**Subject: Independent Fire Protection Review for Cumberland County Civic Center Renovations**

A review has been completed of the fire protection construction documents (CD) set, dated 21 January, 2013, which has been developed to support renovation efforts at the Cumberland County Civic Center in Portland, ME. The documents reviewed included both the fire protection demolition and design drawings, along with the design specifications for the various fire protection and life safety related systems.

SHEET TITLE:	WBRC CAD FILE: 375700 - 0202 Plumbing.dwg
PROJECT No.:	3757.00 GRAPHIC SCALE: 1" = 1'-0"
SCALE:	AS NOTED
PROJECT MANAGER:	JRB
DRAWN BY:	LAC
CHECKED BY:	DMON
SHEET No.:	FP5.01

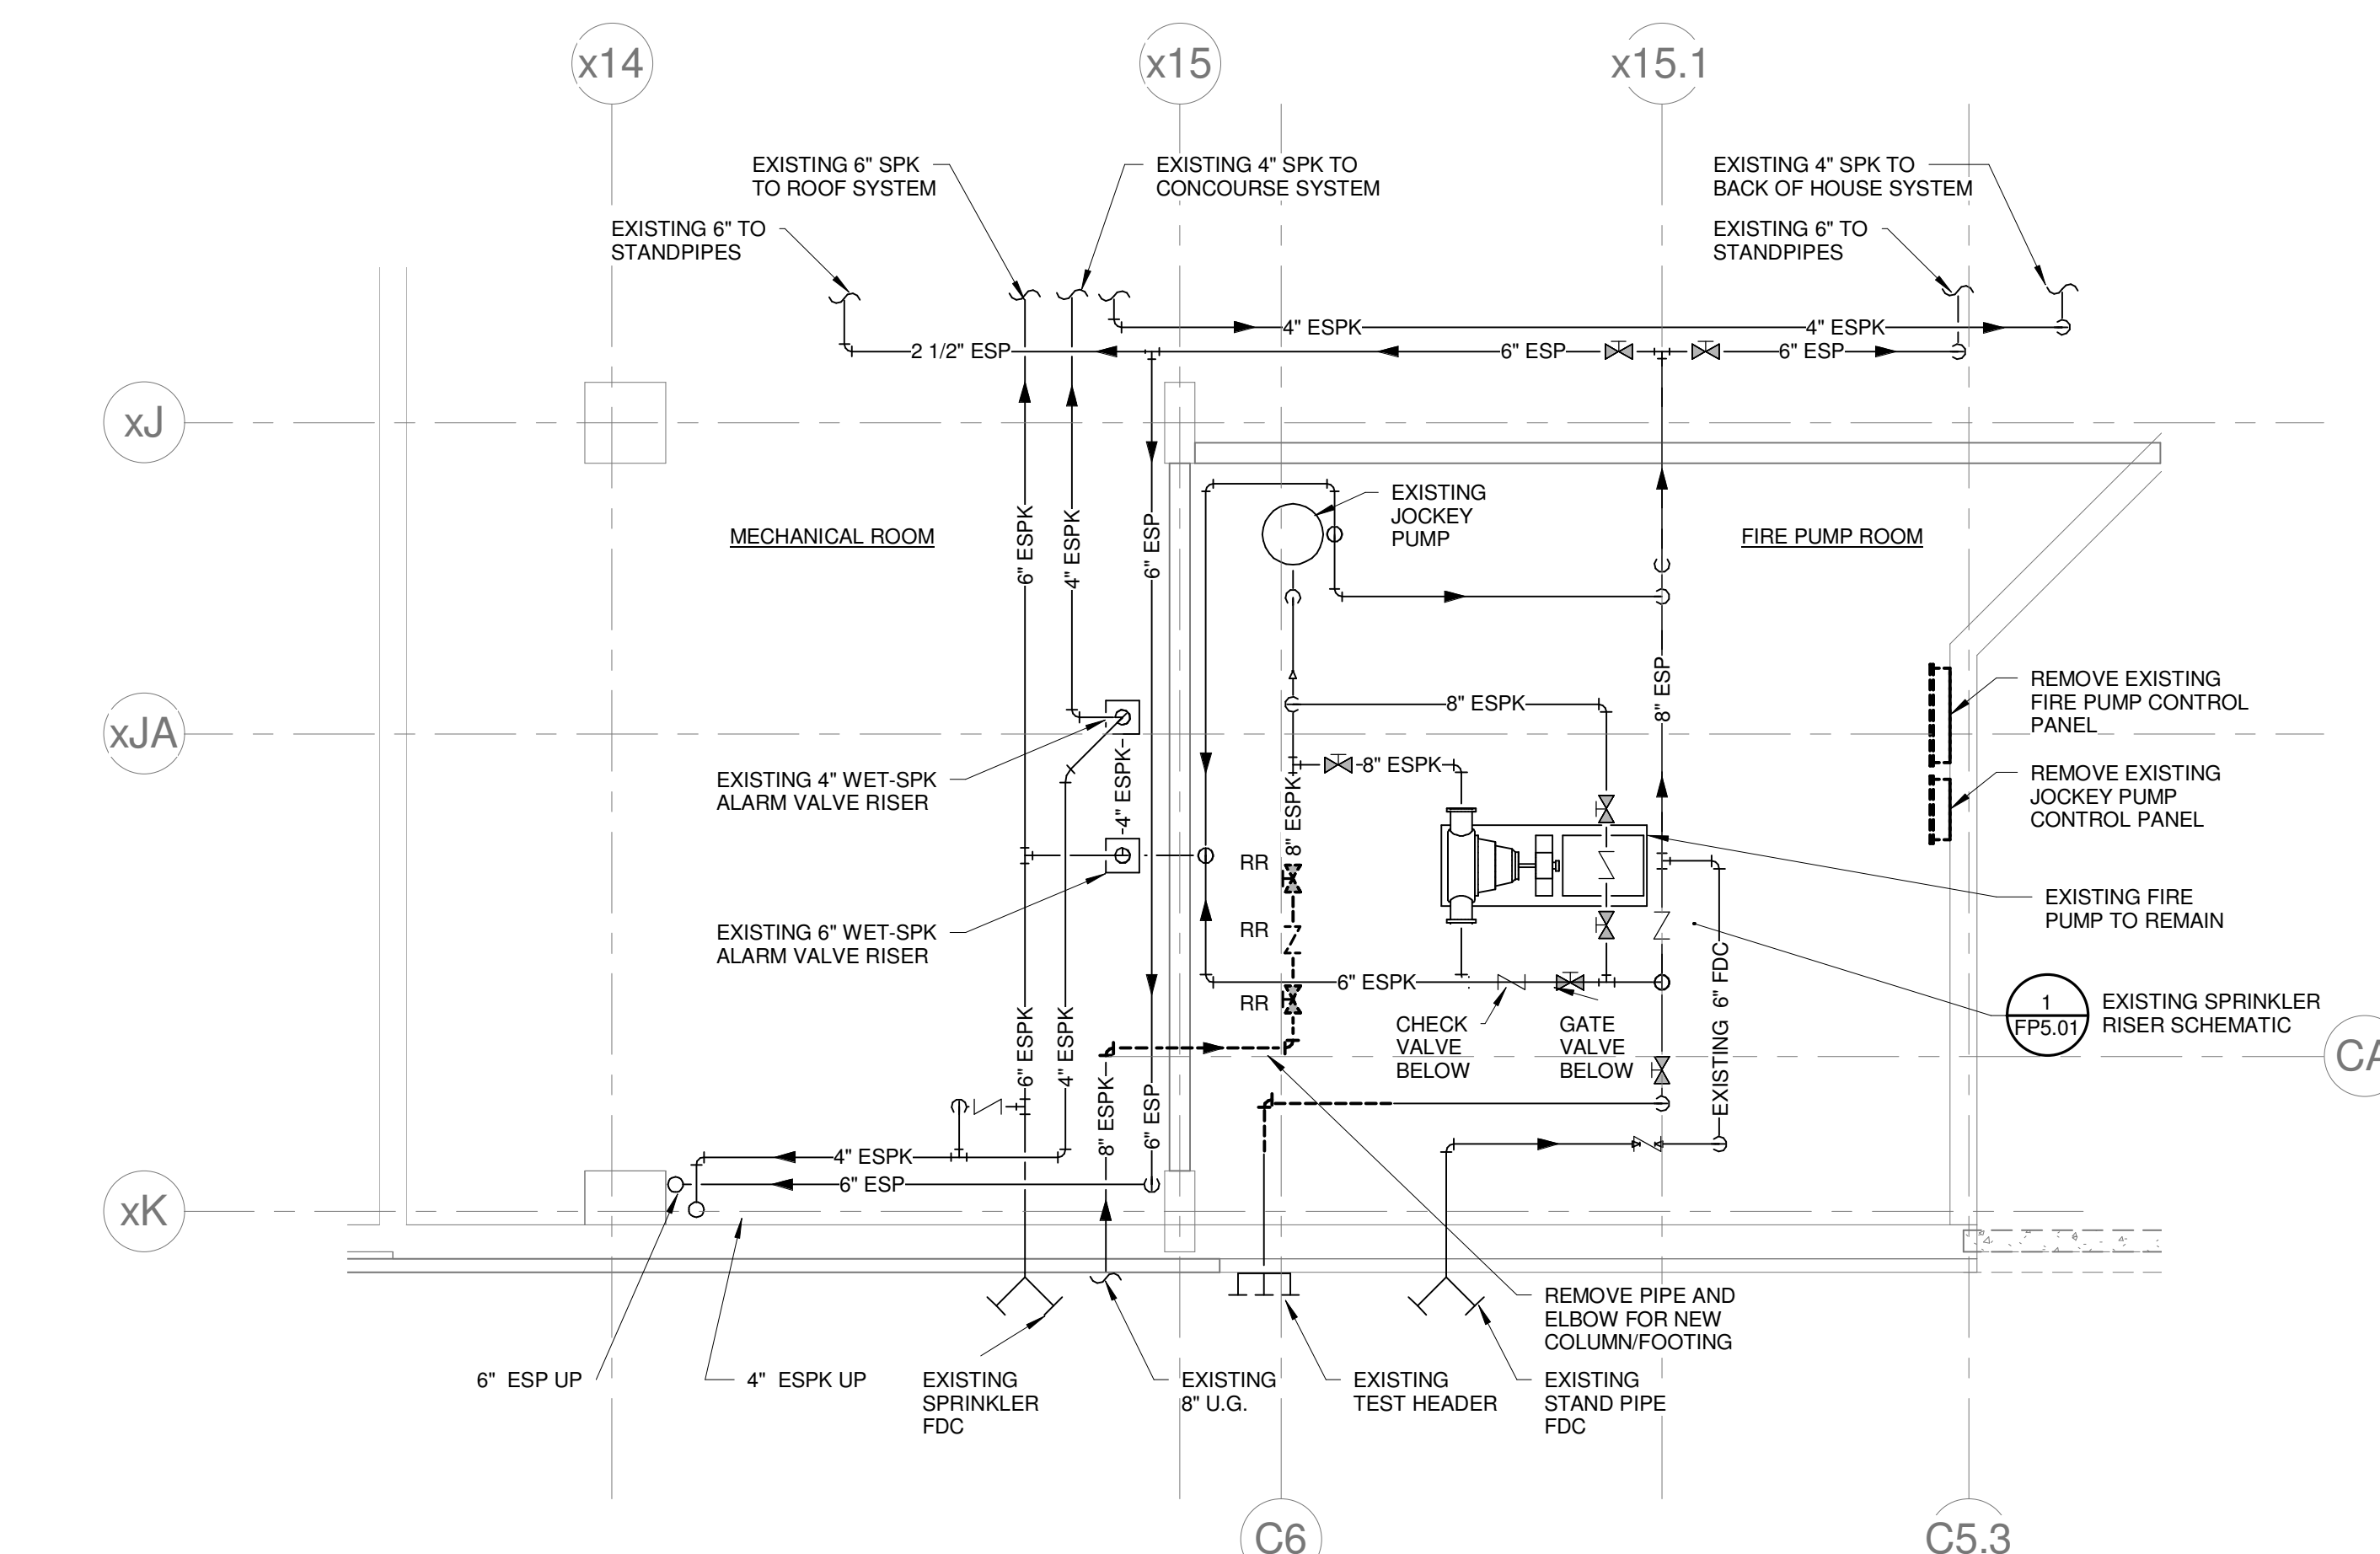
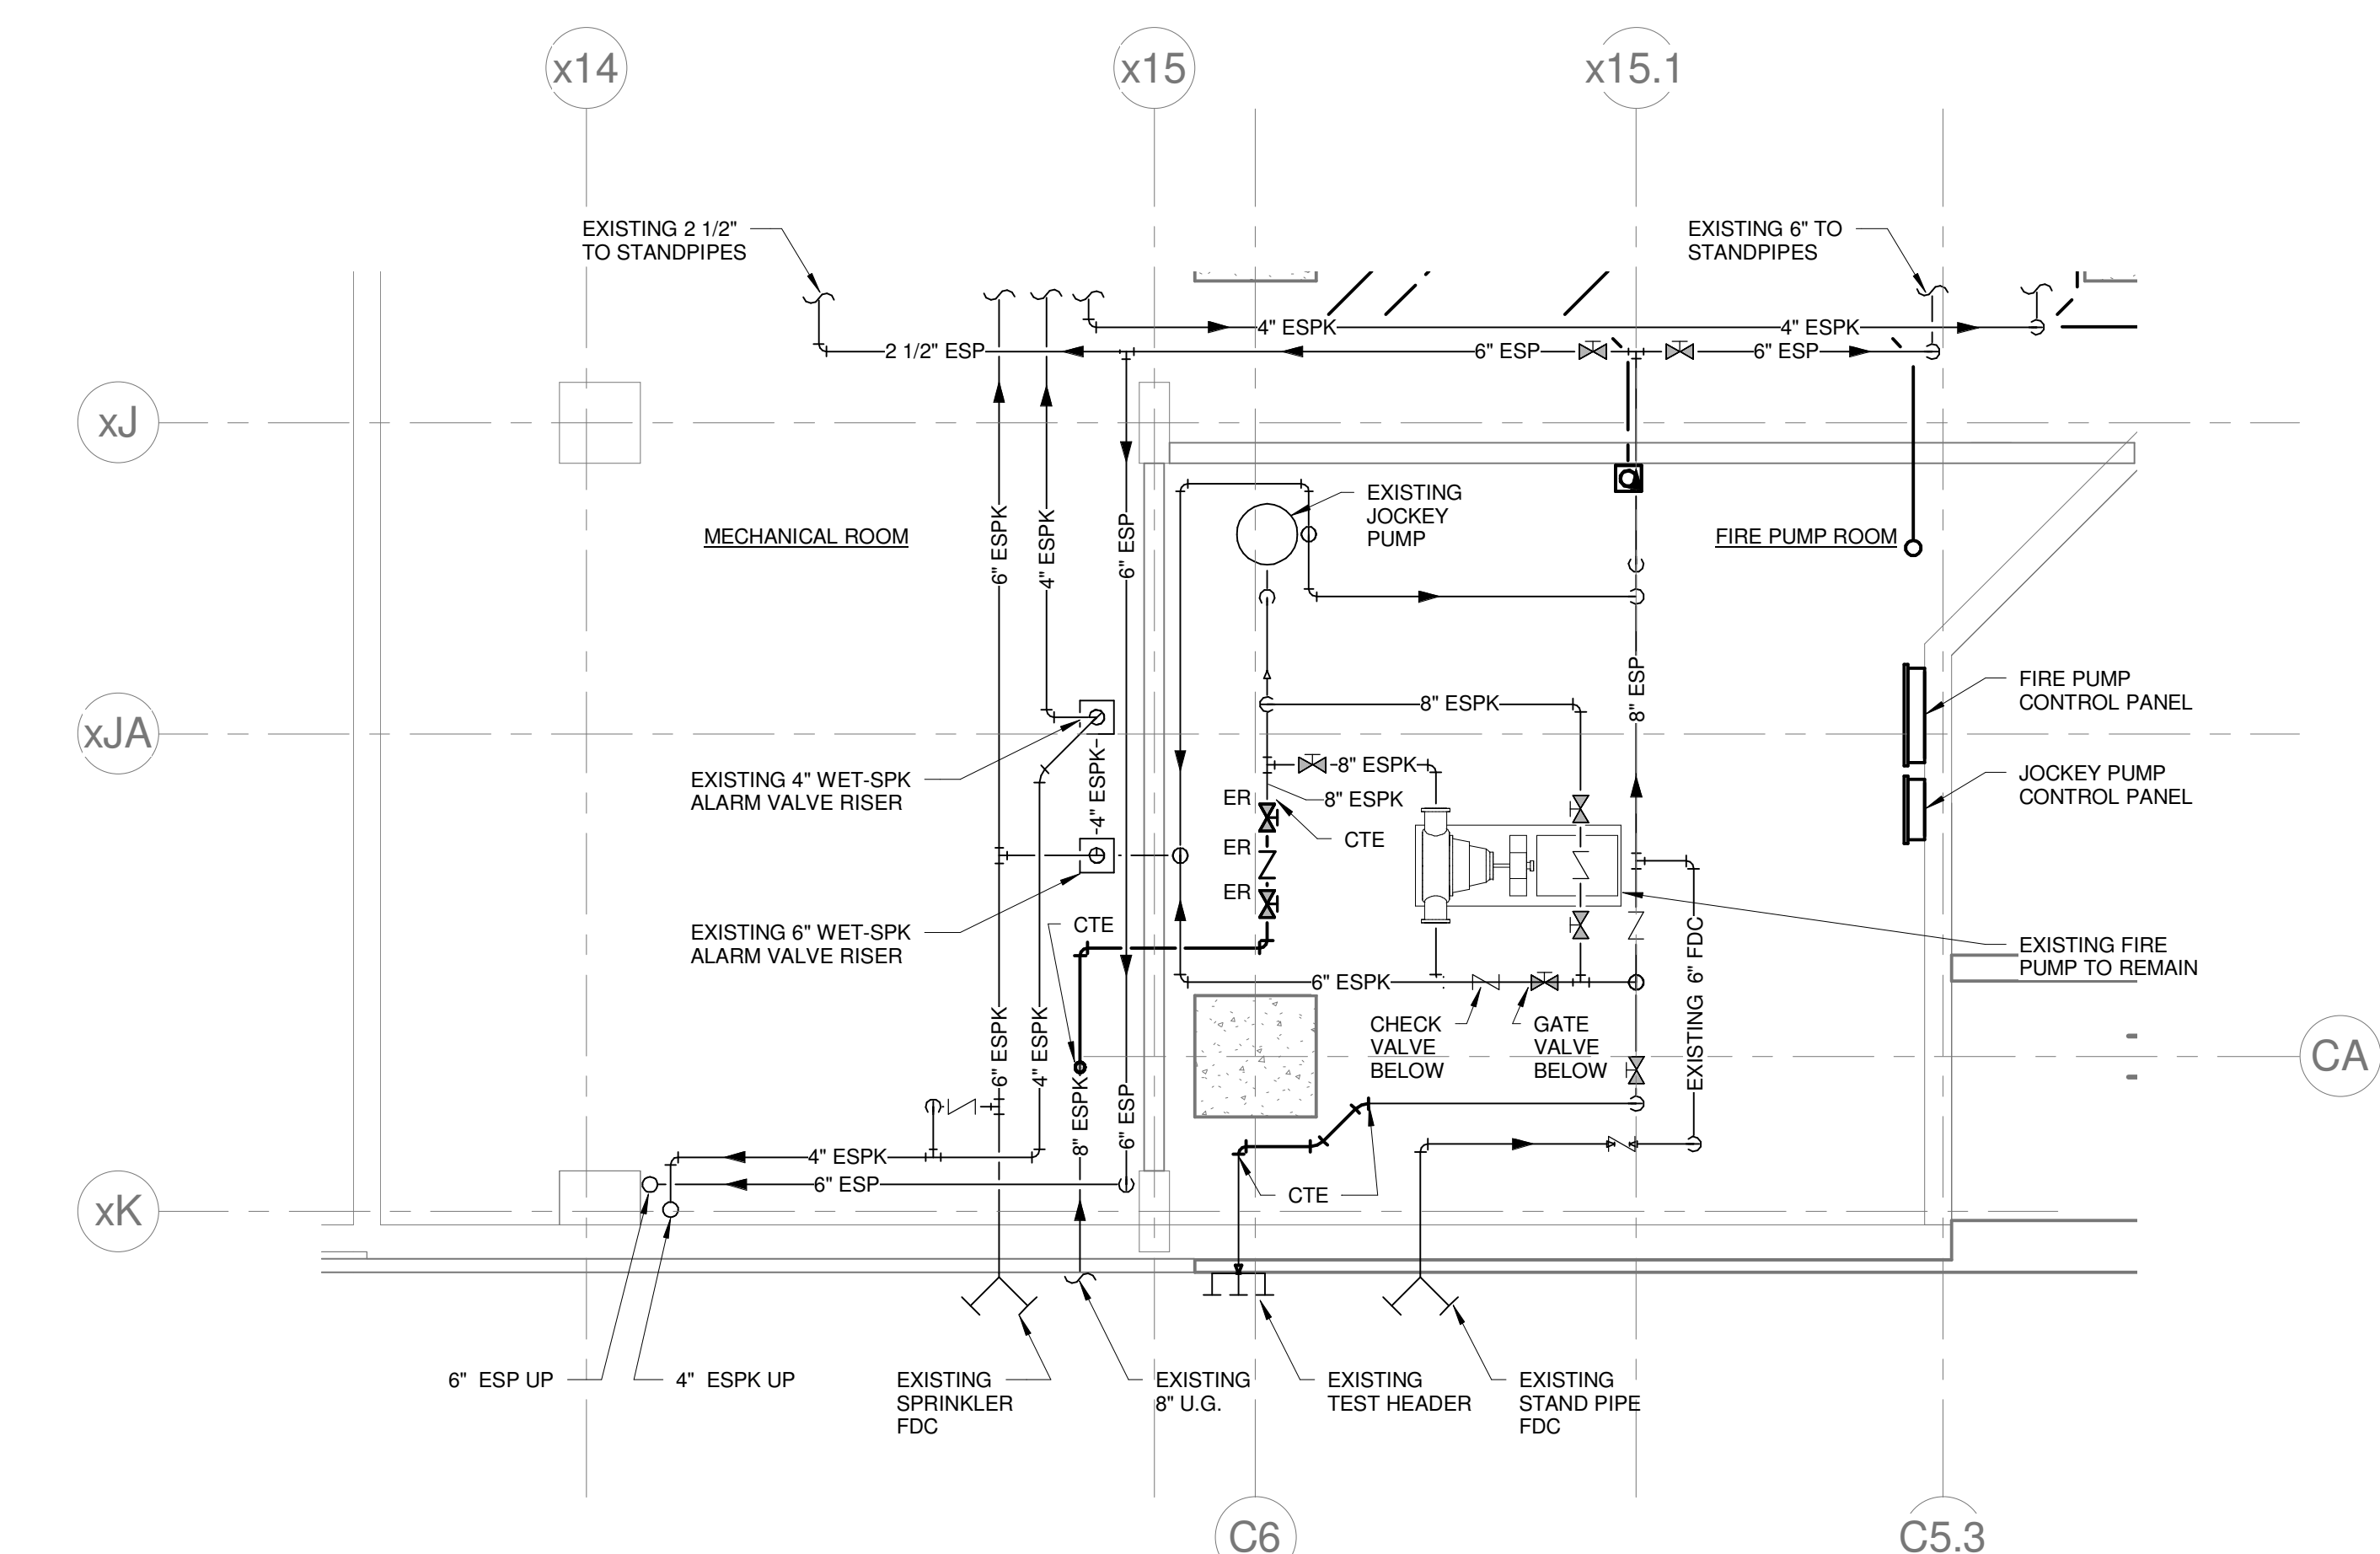
Item 1.4.B should be expanded and clarified. A fire pump does exist for this facility; yet no mention is made of this and how it may, or may not, support the sprinkler systems. This is likely to be a point of confusion for any contractor that may be charged with design/installing these systems. The drawings indicate that the fire pump does supply the sprinkler systems. The specific flow characteristics for the fire pump (pump rating) should be provided, such that it can be used to support the necessary hydraulic calculations.
